21 January 2025

SUBJECT: MAYFAIR SOLAR FARM (SSD-60074458) ADVICE - ENVIRONMENTAL IMPACT ASSESSMENT

Project Overview: The Mayfair Solar Farm, proposed by Elgin Energy Pty Ltd, is a utility-scale solar farm with a 60MW capacity, including a Battery Energy Storage System (BESS) of 240MWh. The project will be located at 204 Jacksons Lane, Stubbo, NSW.

TYPICAL ROAD CROSS SECTION 8 METERS
JACKSONS LANE UPGRADE

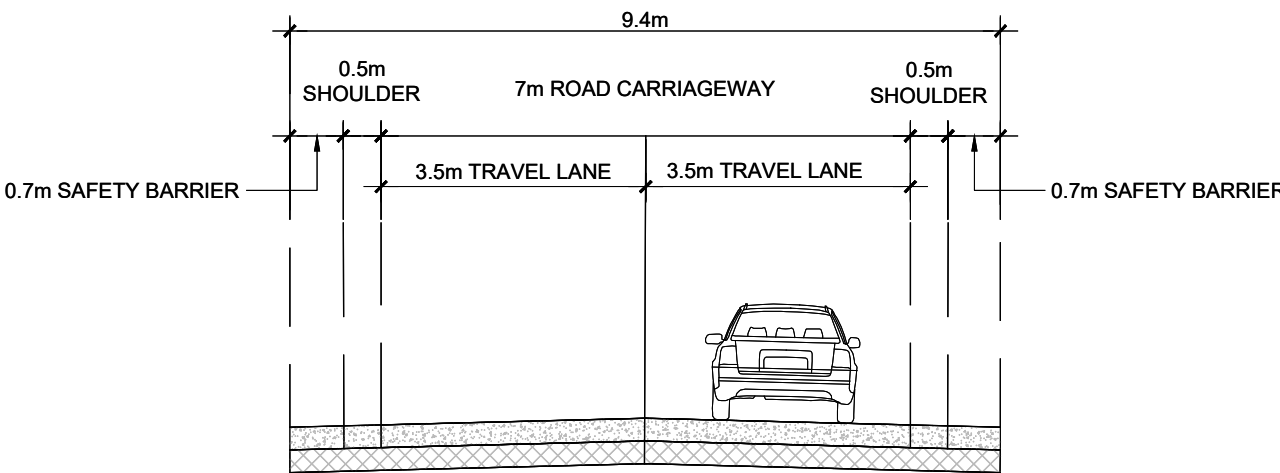
The haulage route includes Black Lead Lane, yet no road safety assessment has been done of this road, the assessment has been done on the b-double route of Rouse St. The TIA does not include road upgrades proposed for roads other than Jackson Lane or the standard to which they will be upgraded.

All road upgrades shall be considered in line with Austroad Guideline for road design and be proposed roads and intersections to be upgraded should be included in the TIA.
